EP/62/20/DOC

Approval of details reserved by condition imposed under ref EP/179/18/PL relating to Condition Nos 3 - surface water drainage, 4 - visibility splays, 5 - car parking & turning arrangements, 6 - covered & secure cycle parking, 7 - materials & finishes, 8 - hard & soft landscaping and 10 - existing wall to south

Scales: 1:50 1:200
No: 2386/01/12

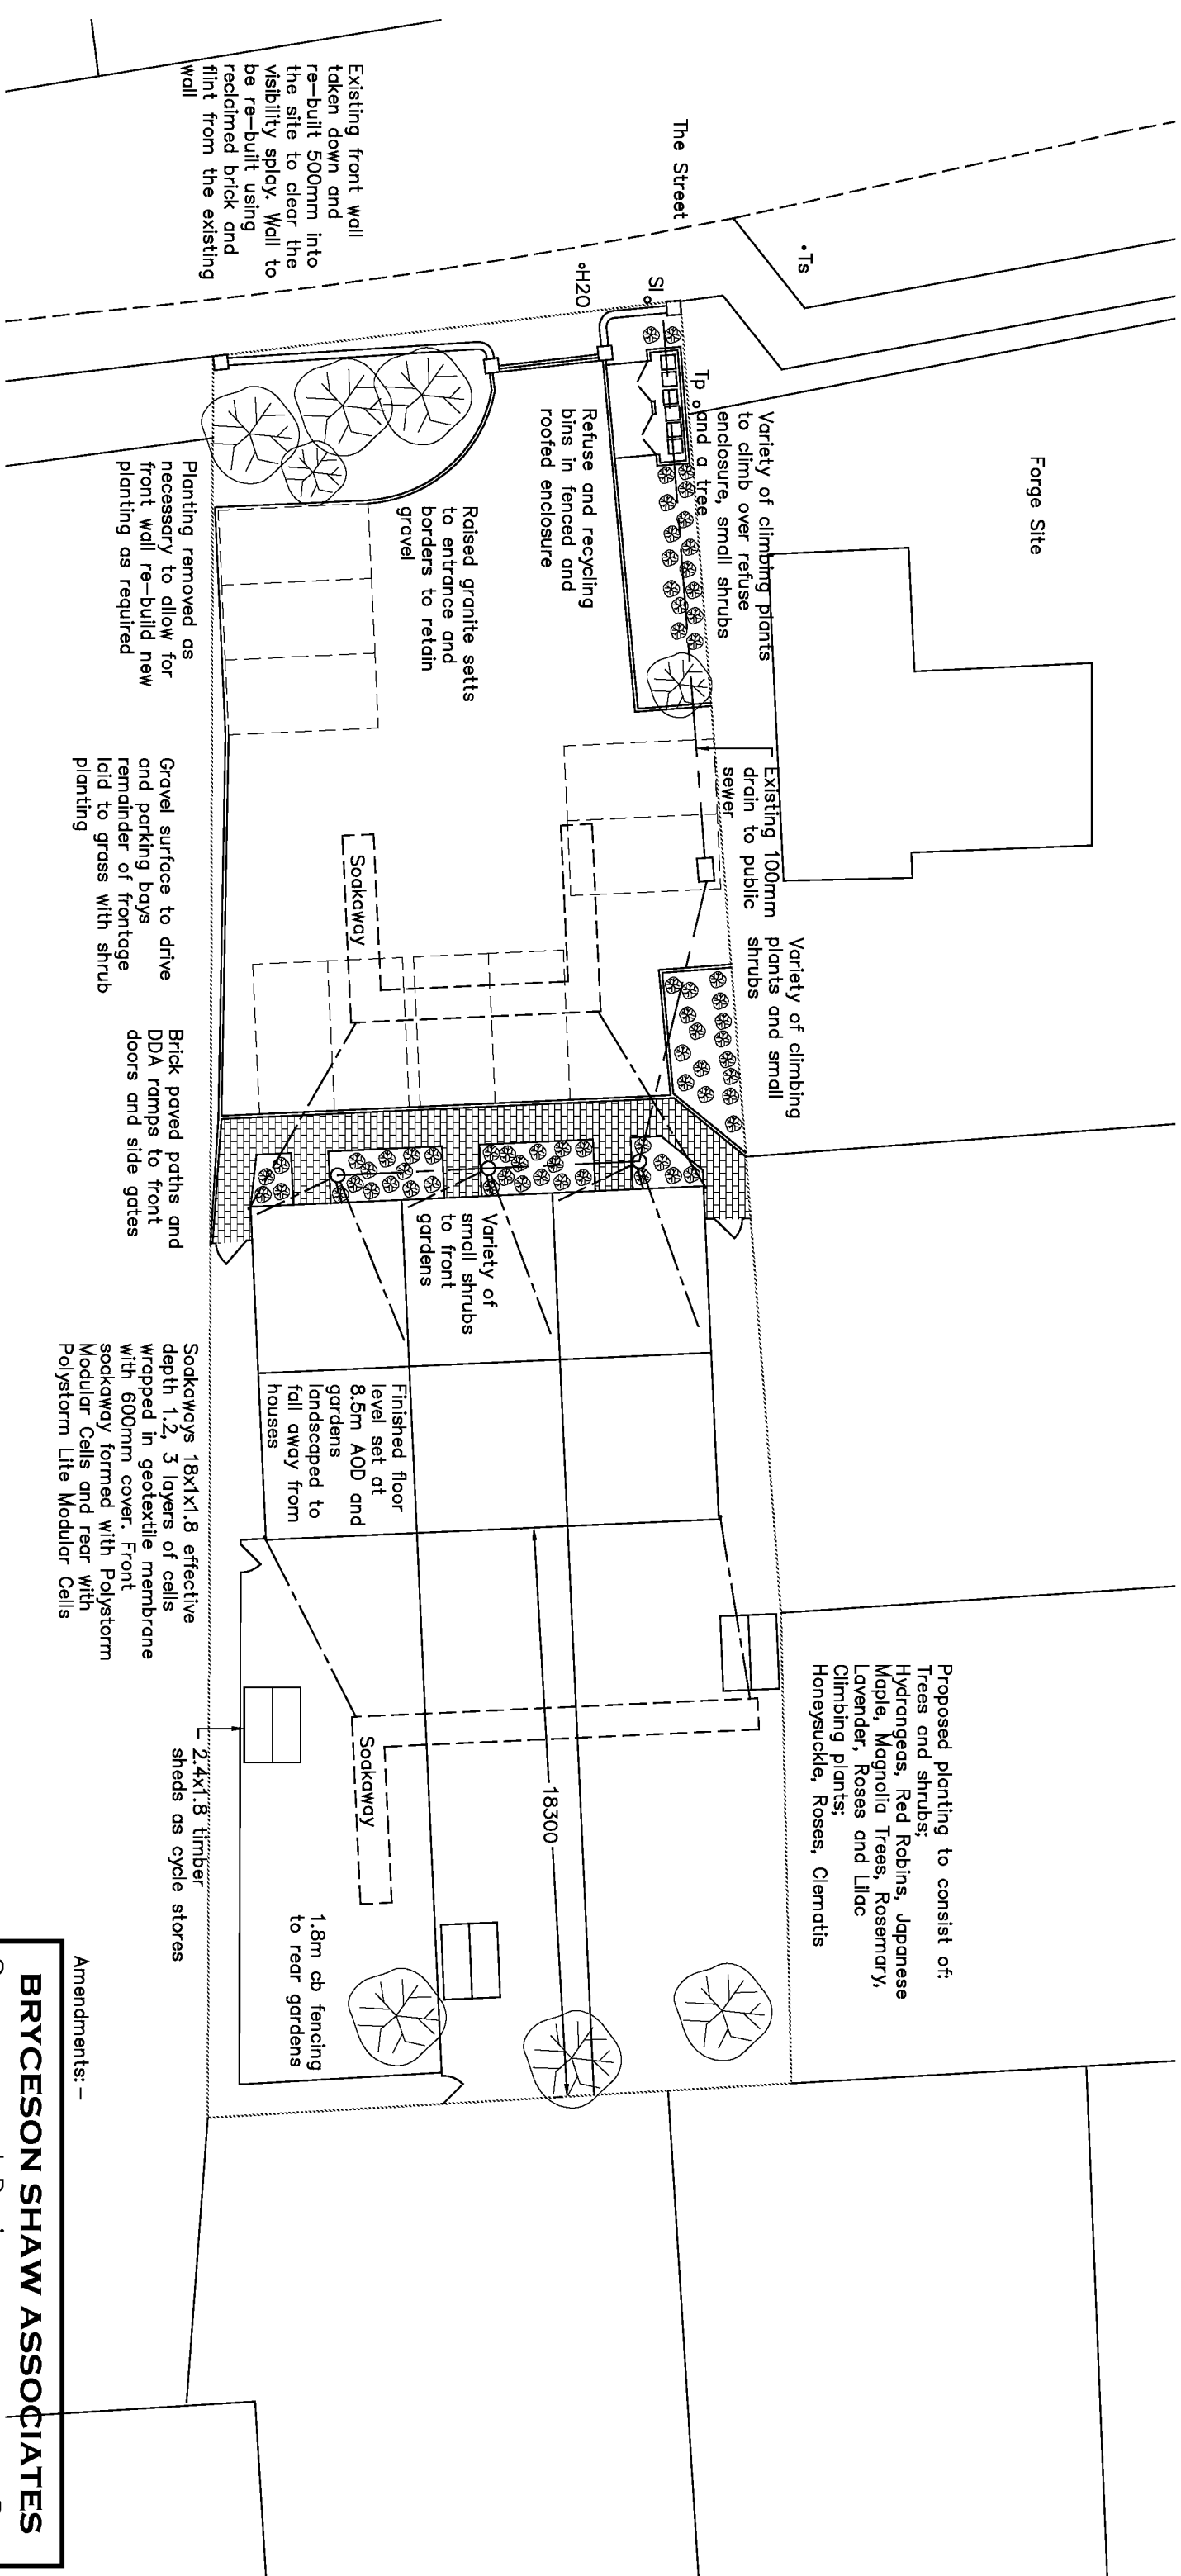
If the boundary wall is to be re-built it will have to be based on the pictures provided. This implies that it will be an attractive coursed wall where the flints are very closely spaced with little mortar visible.
